Mr A Wood
Planning Department
Arun District Council

Dear Mr Wood , Ref LU/91/19/PL Change of use , Littlehampton Sea Front

SITE LOCATION PLAN AND
BLOCK PLAN - SITE C&D

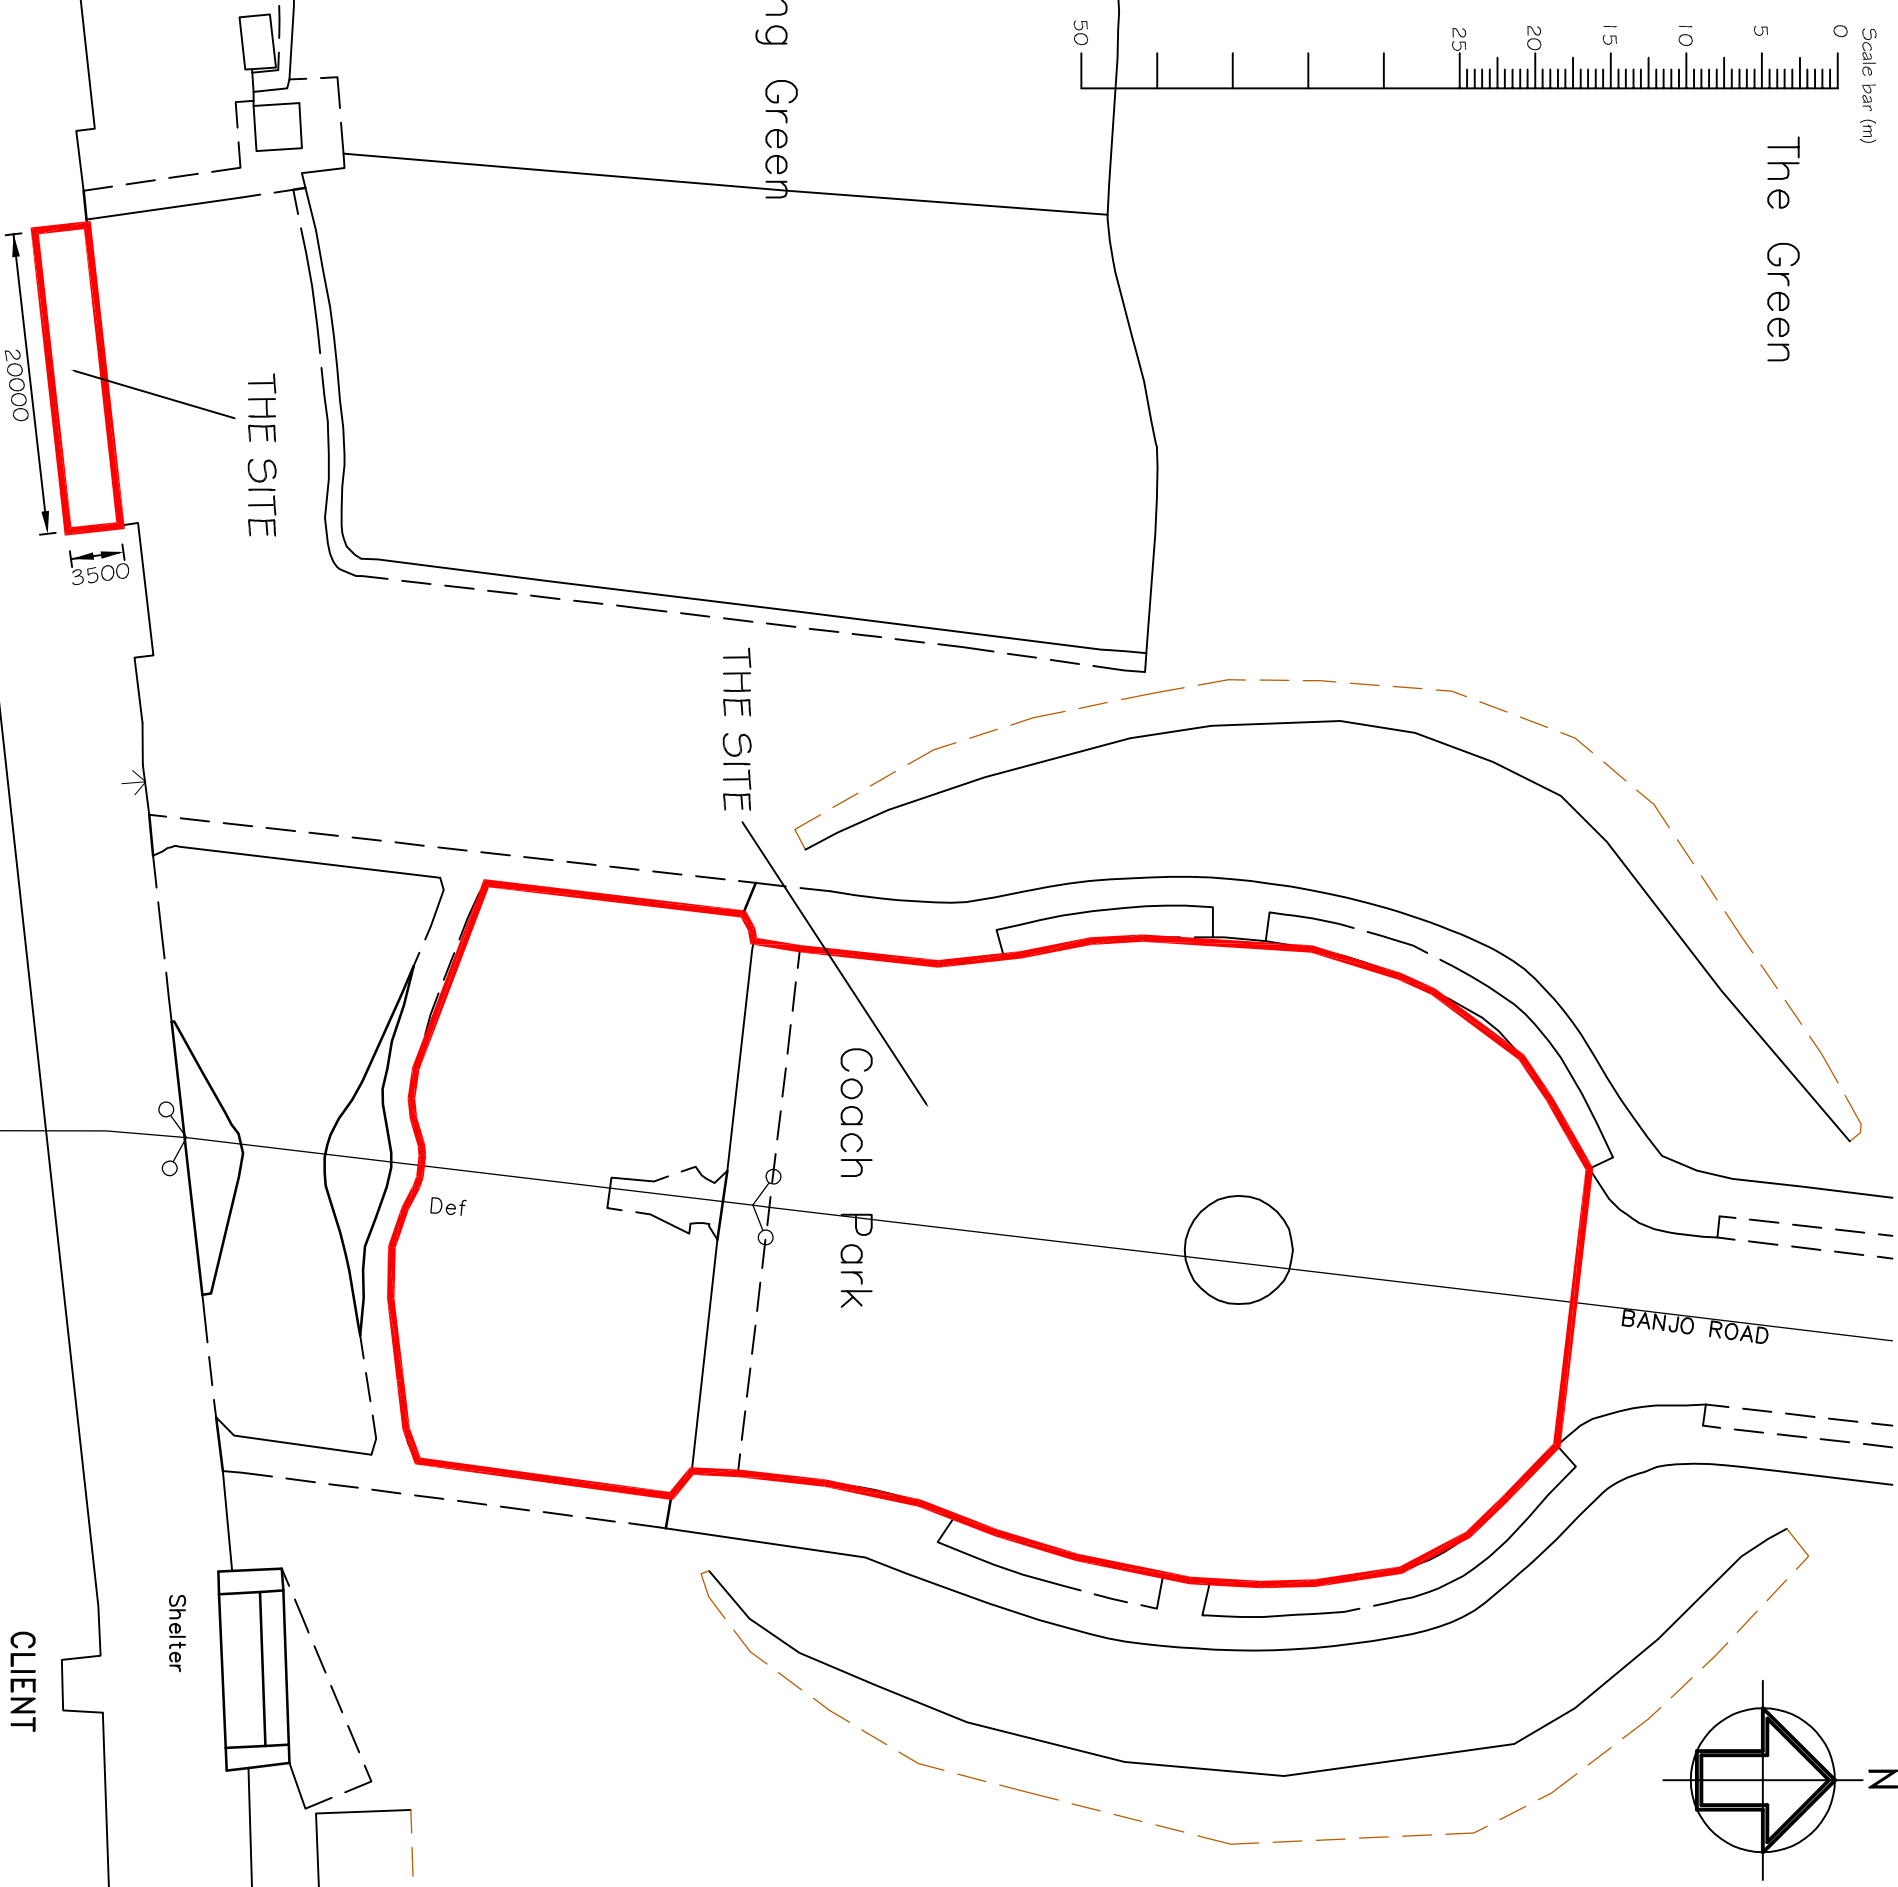
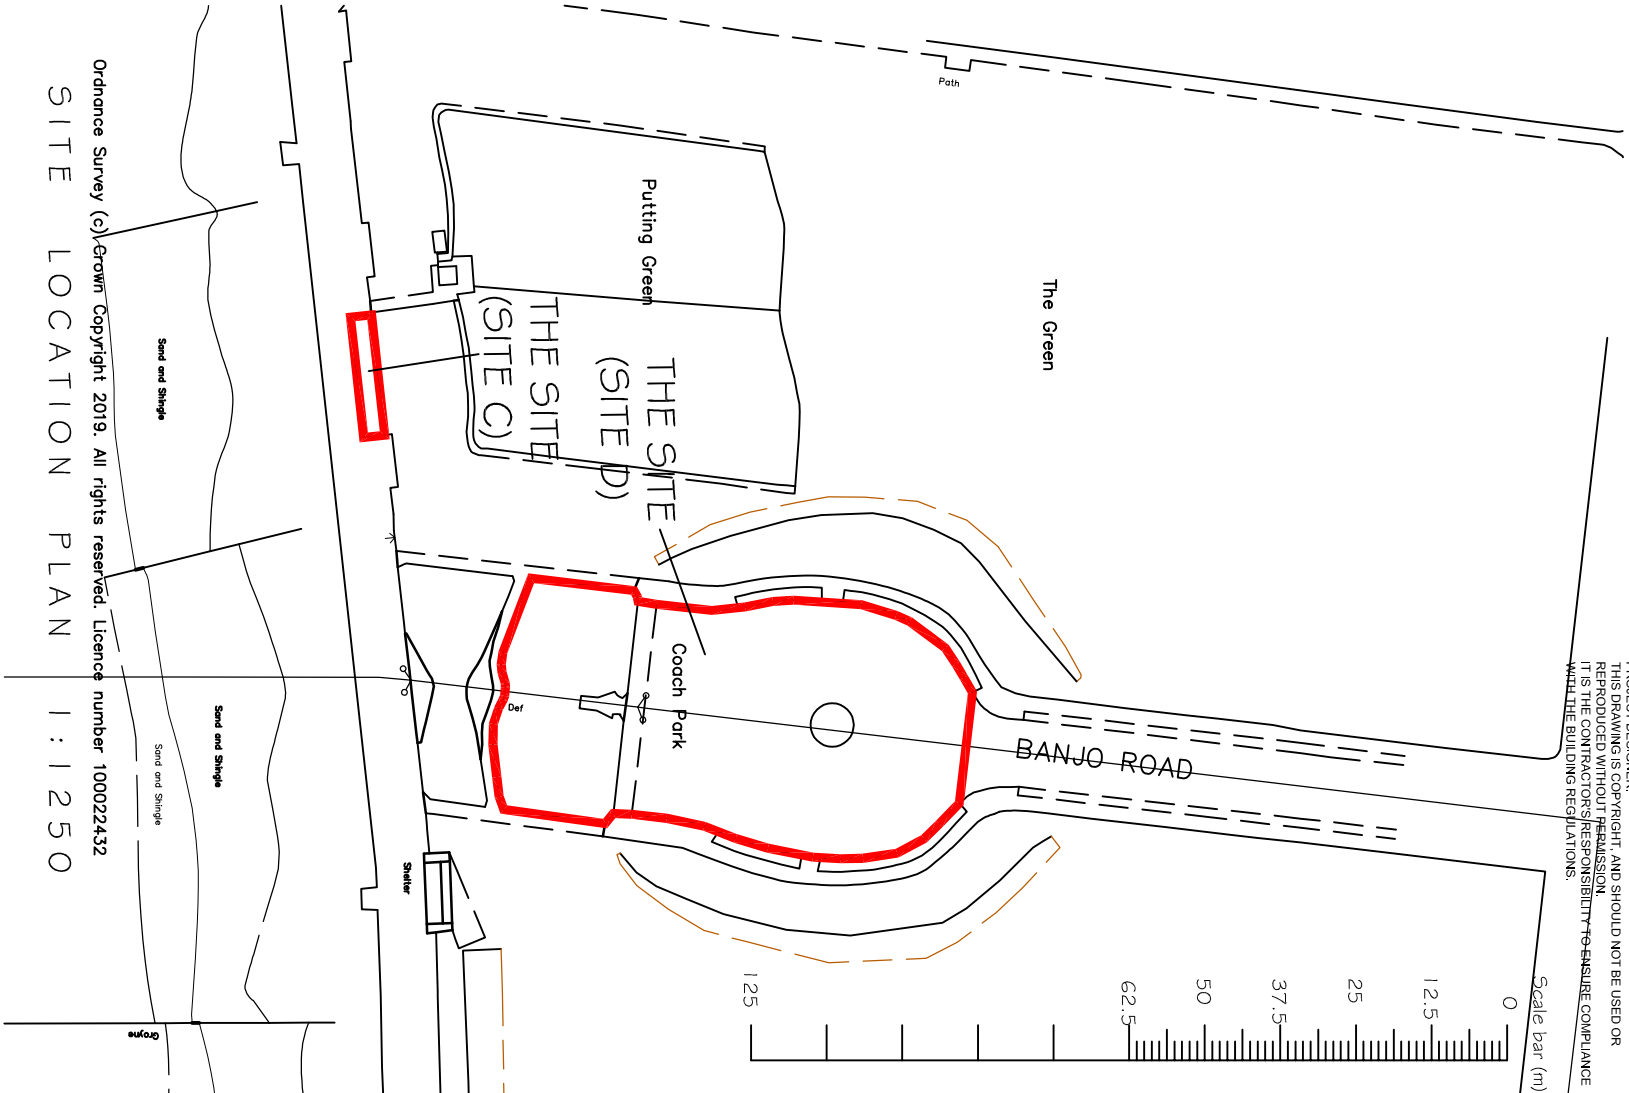
I am the owner and operator of the promenade train and the proposed sites C and E which is to have retail units is projecting up to 3500mm across the promenade .This area along the seafront is fairly narrow and can be very congested at peak times.The train at very regular intervals runs the length of the promenade along the central white line and if running in a straight line is 1400mm in width .The clearance between the edge of the train and the edge of the retail area for site C is 700mm and for site E is 1100mm.
